3 May 2011

**Report on the Proposed Residential Subdivision
At Gwandalan by Lakeside Living Pty Ltd**

DETERMINATION OF MAJOR PROJECT NO. 10-0205

Gwandalan Residential Subdivision proposed by Lakeside Living Pty Ltd

Figure 9. Cross sections proposed for Road 1 (top) and Road 6 (bottom)

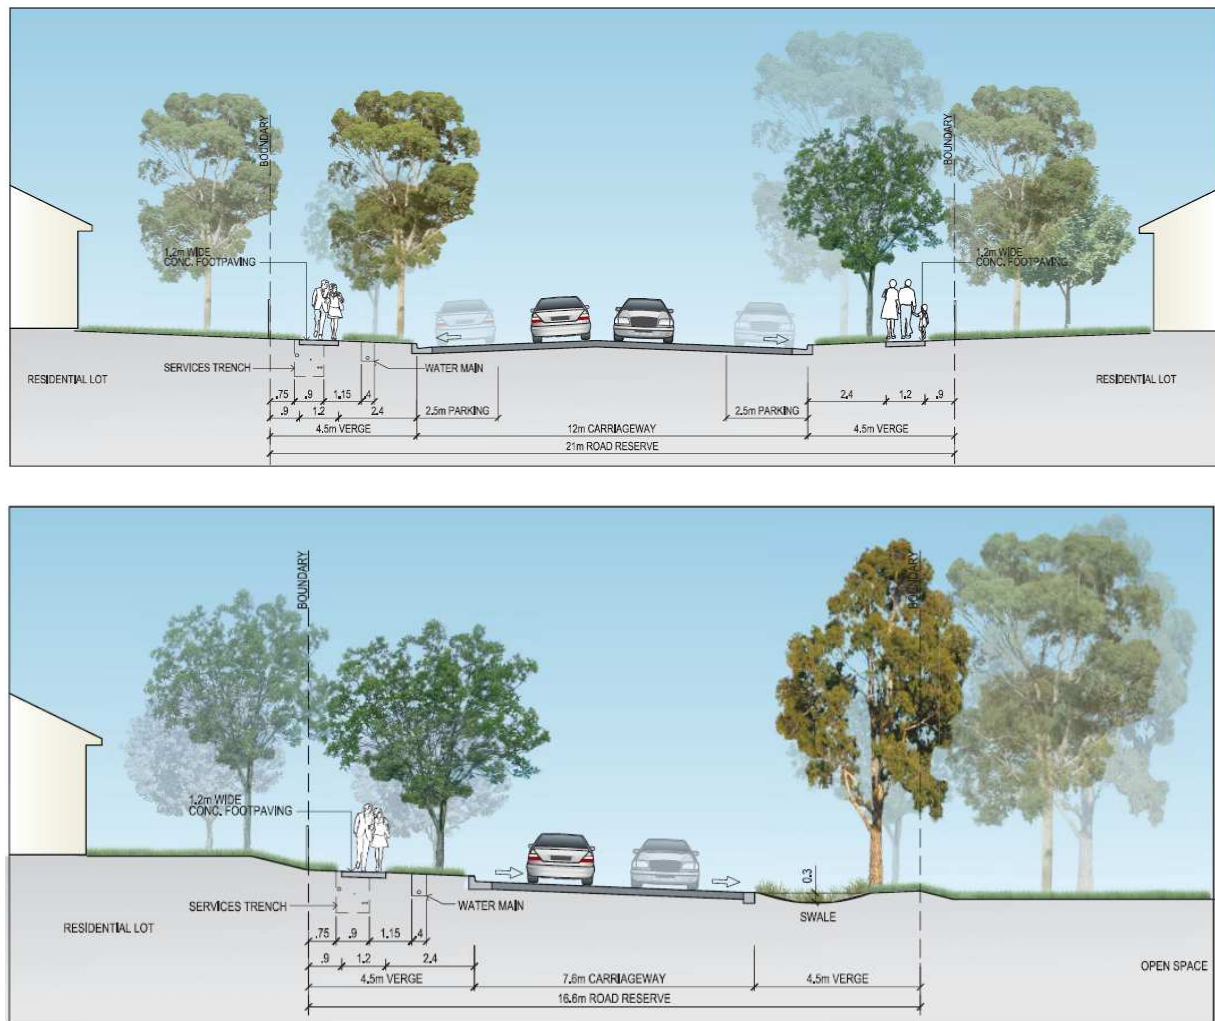
- Increased bushfire APZs for Lots 129 to 138 to 35m;
- Road 6 to be widened from 7.6m to 8m;
- An easement to be created for the stormwater system on the residual lot for management by Council;
- Management plans are required to manage and mitigate construction impacts including impacts on flora and fauna, and erosion and sediment control;
- Detailed plans to be submitted for road works, stormwater and public domain landscaping;
- Utility services to be provided to the residential lots prior to the issue of subdivision certificate; and
- Provisions for regional and local contributions to be made.

- (1) The Asset Protection Zones for Lots 129 to 138 shall be a minimum of 35m. The proponent shall demonstrate that the lots are capable of accommodating a dwelling;
- (2) The carriageway of Road 6 shall be a minimum of 8m; and
- (3) The carriageway of Road 10 shall be a minimum of 6m.
- (4) A copy of the amended subdivision plan shall be submitted to the Council.
